BAL ARTS MUSEUM

SIGNAGE PRE-APPLICATION

BUILDING PERMIT REPORT

DATE: 1 July 98 ADDRESS: 122 Spring ST, 039-D-004
REASON FOR PERMIT: Signage
BUILDING OWNER: Arthur Alehsine
CONTRACTOR: Oscar Mokemp
PERMIT APPLICANT: _____
USE GROUP Signage BOCA 1996 CONSTRUCTION TYPE _____

THE AFRICAN TRIBAL ARTS MUSEUM

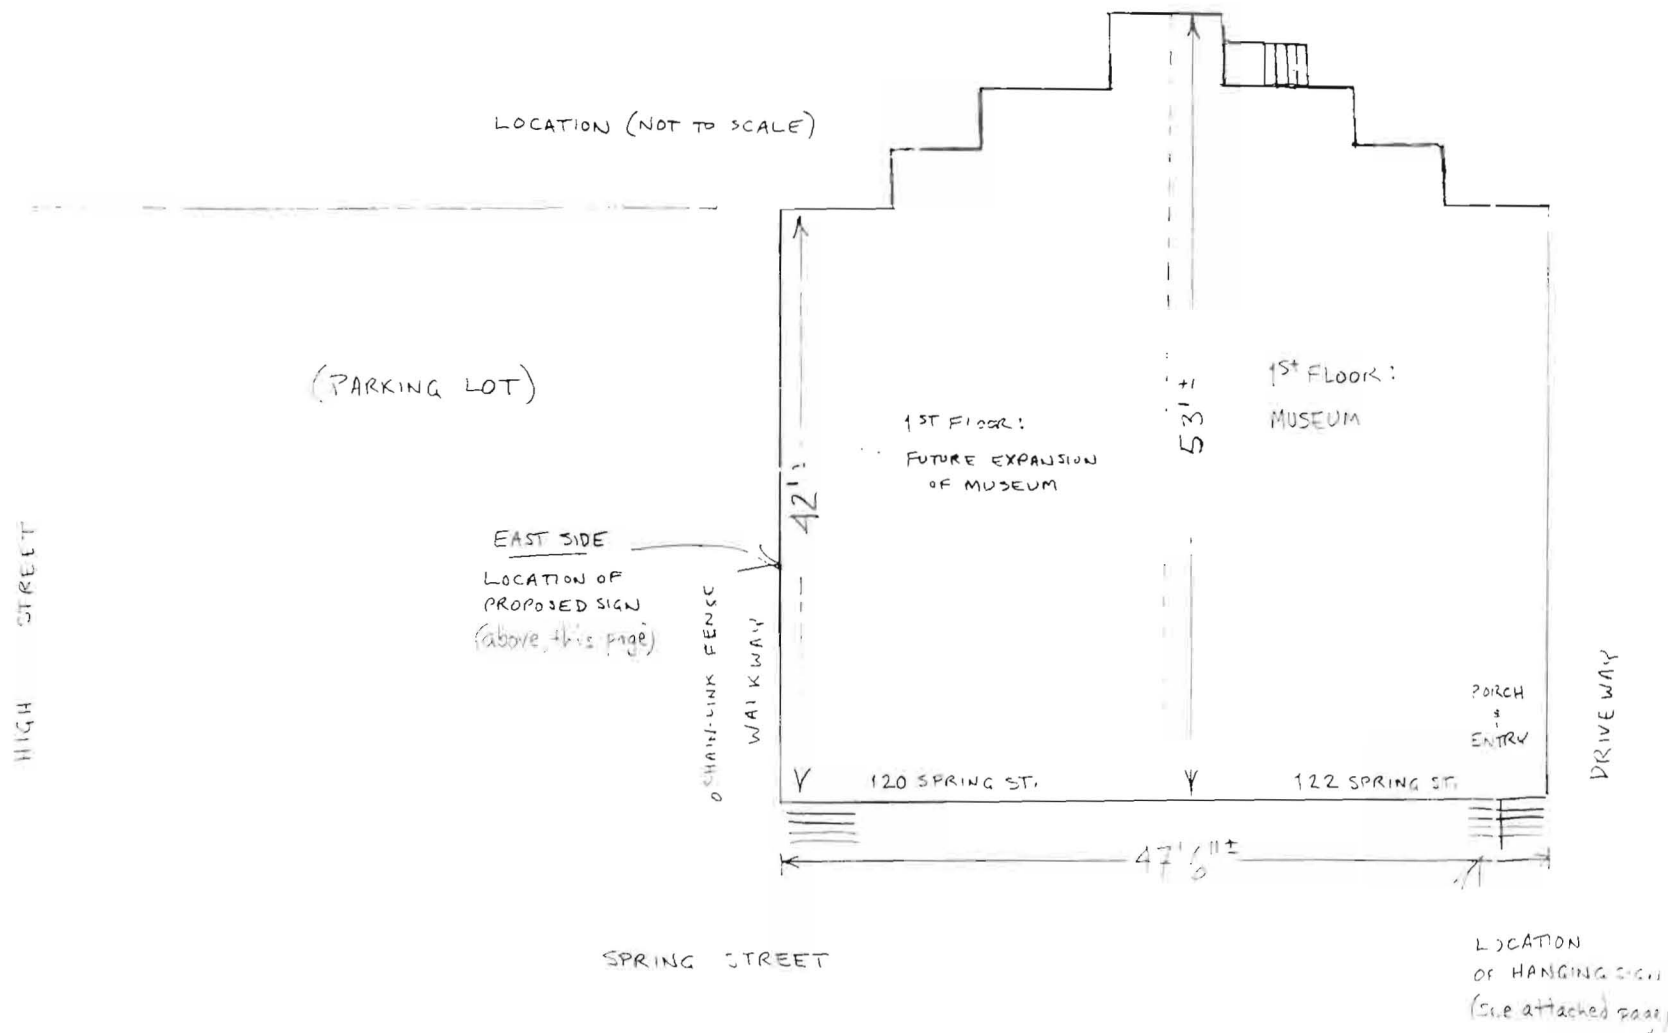
29. *Wall sign denied as per Historic Preservation -*
30. *Your proposed sign application did not have any structural details - Please submit these for approval before sign is hung.*
